Mount Pleasant Coal Mine (DA 92/97 MOD 3) – Response to Submissions

I refer to your email of 13 October 2017 inviting comment on the Response to Submissions (RTS) exhibited on the NSW Department of Planning & Environment web site in relation to the Mount Pleasant Coal Mine Optimisation Modification (the Project).

**Figure 5: Comparison of predicted incremental annual average PM<sub>10</sub> concentrations for the Modification and Modification 3 in Scenario 2 (µg/m<sup>3</sup>)**

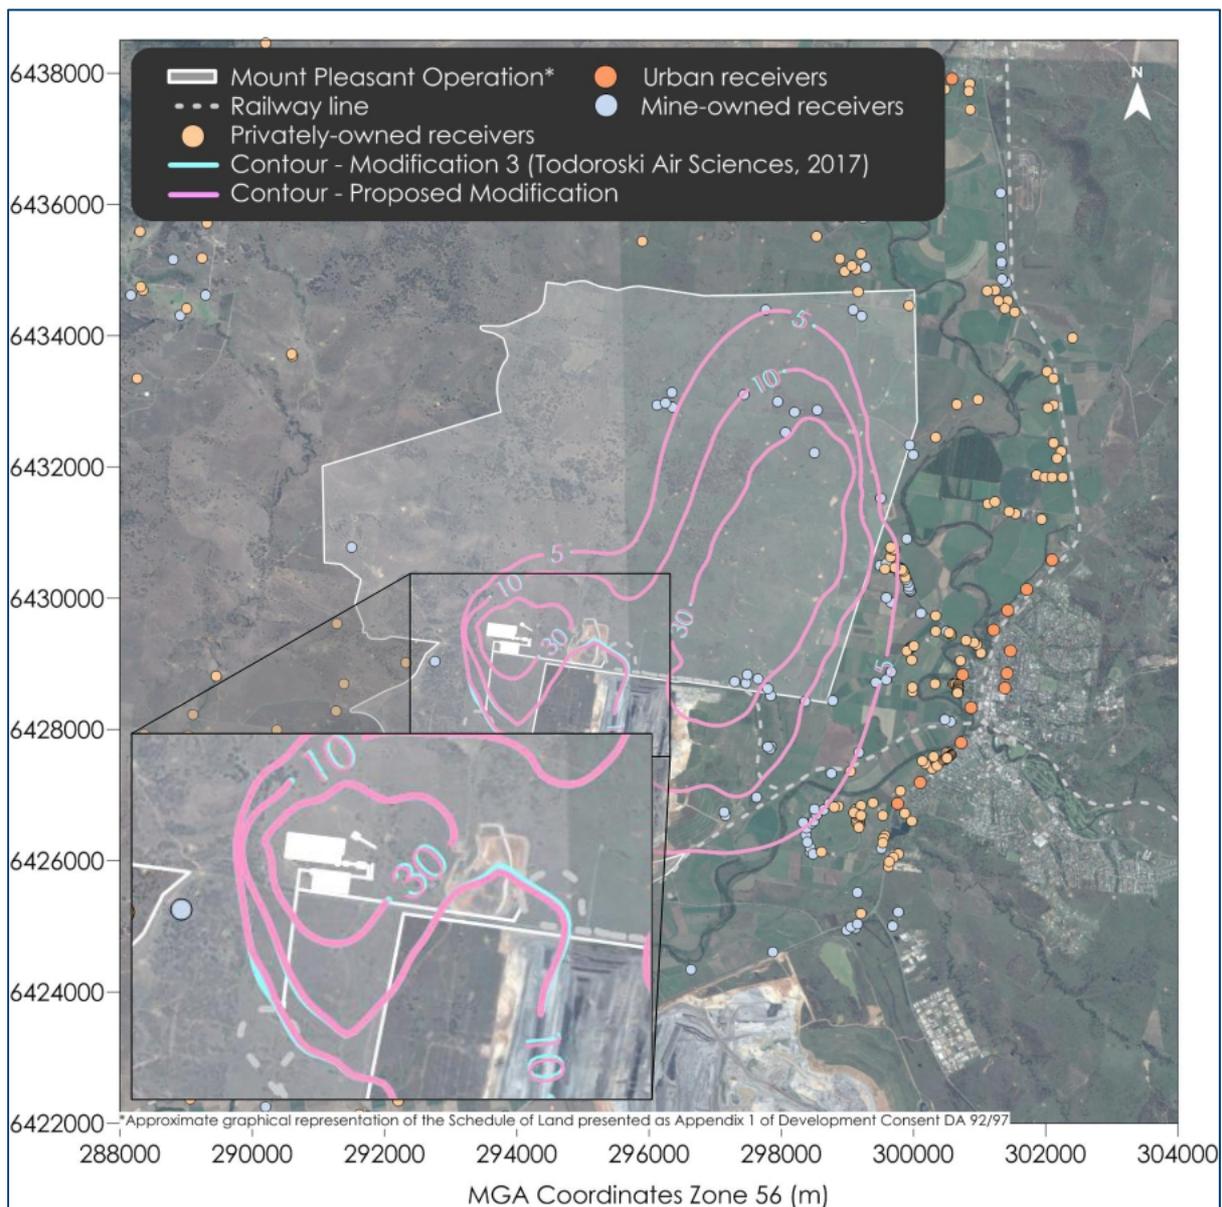
Both EPA and NSW Health advised that the proponent had used an outdated goal for annual PM10 levels with nine private residences exceeding the current goal of 25 µg/m³. The response from the proponent was that the current model is overly conservative and does not accurately predict actual impacts. If the current model does not accurately predict the geographical coverage of the 25 µg/m³ isopleth it would be useful to review the methods and produce a revised figure.
